**Deadline 7 Submissions**  
**Preston Farms Ltd ("PFL") and TCS Biosciences Ltd ("TCS")**

## Rosefield DCO Application examination

### Deadline 7 (final deadline) submissions/evidence of Preston Farms Limited (PFL) and TCS Biosciences Limited (TCS)

TITLE:
 FIGURE 3.9D
 INDICATIVE CONSTRUCTION AND OPERATIONAL
 ACCESS - PARCEL 3

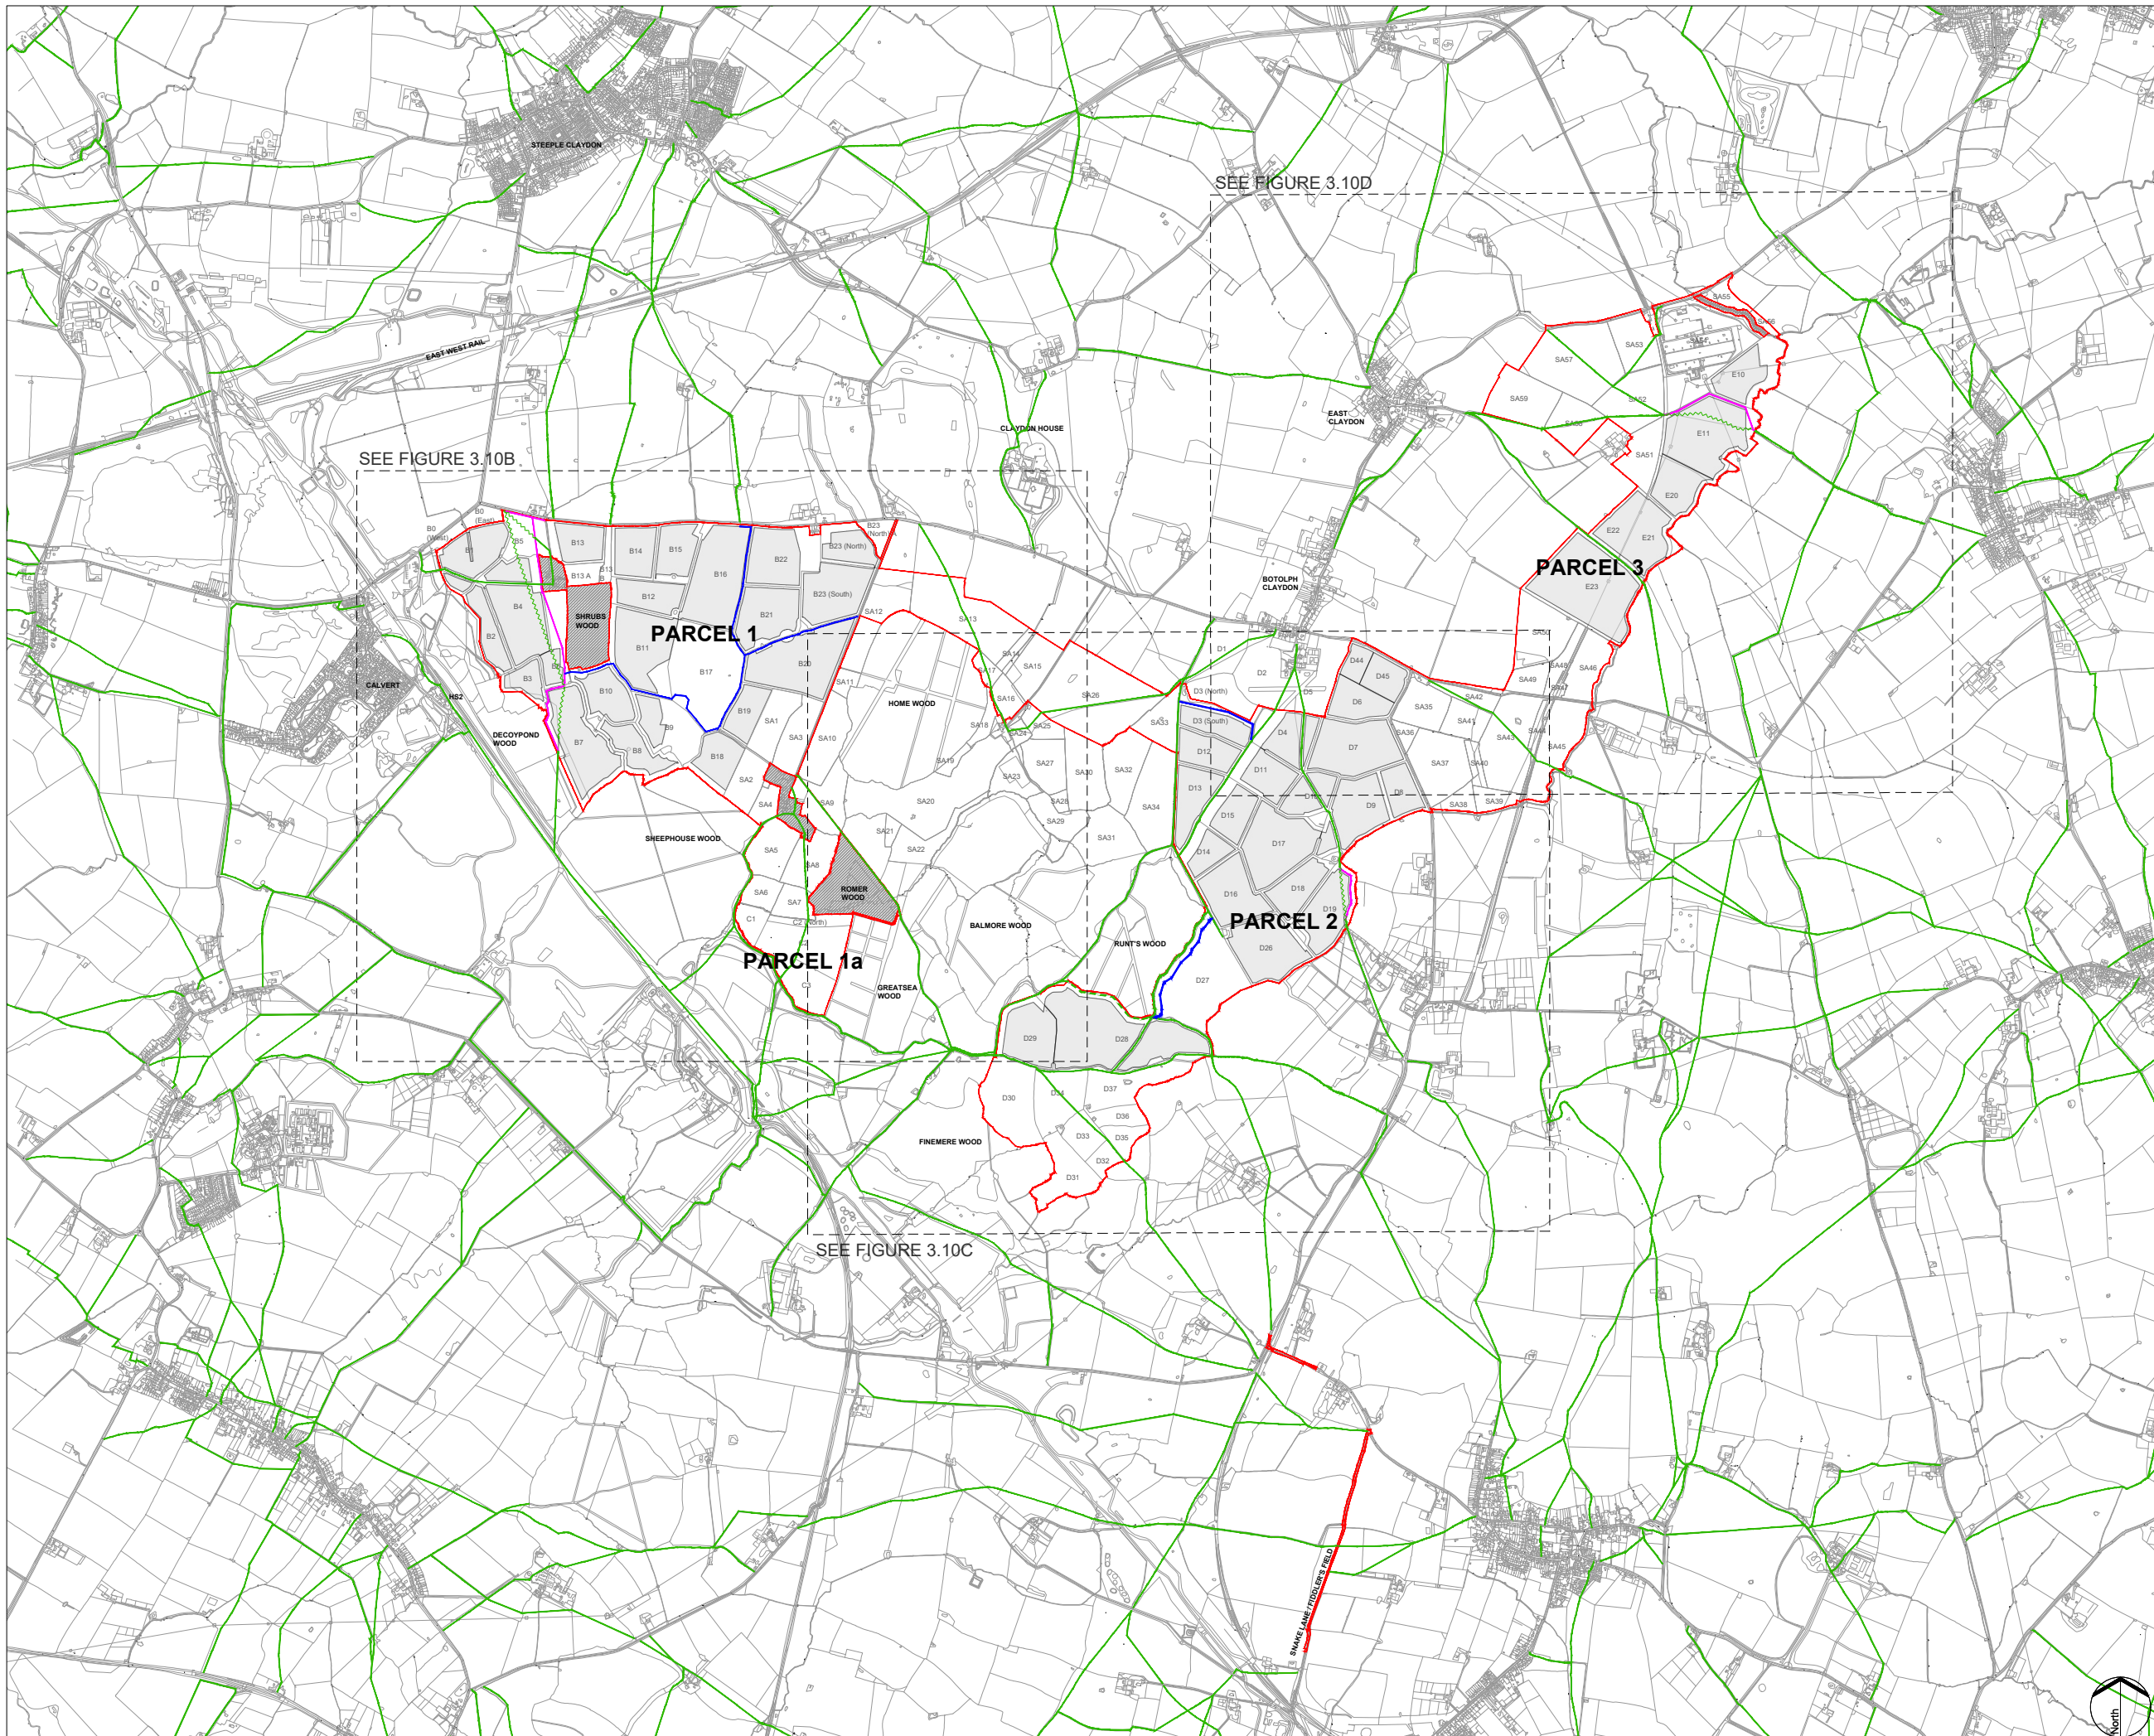
33. There has been a slight change here from the Applicant's Deadline 5 position, but as ever it is limited and grudging. The Applicant now says that for the operational stage it will only use the access off the Granborough Road into Plot 6/12 (specifically, what is known as field SA46) for HGVs (see **REP6-071** para.3.3.2). There can be no justification for this insistence on continuing to expose the livestock to stress and contamination risk. Given such movements will be rare, the claimed 'safety case' against the alternative Winslow Road route cannot outweigh the risk to the PFL/TCS operation.

34. If, contrary to PFL/TCS' case, there is to be a Granborough Road access, for construction or operation, then it must be moved as far eastwards in field SA46 as possible. The Applicant was to speak to Buckinghamshire Council regarding visibility splays (PFL/TCS know the road very well and are convinced visibility would not prevent a movement eastwards). There is still no explanation from the Applicant of its vague references to 'environmental' or 'ecological' constraint regarding the brook: the Works plans show separation from the brook already, and that is surely sufficient (the Applicant does not suggest the brook has any particular designated status of relevance).

36. Necessary modifications to the Works plans and to the draft DCO are attached. The modifications to the Works plans show, first, PFL/TCS' primary position, with no access off the Granborough Road (labelled "Version 1)", and, second, PFL/TCS' secondary position, with access off the Granborough Road but moved to the east (still with ample separation from the brook) (labelled "Version 2").
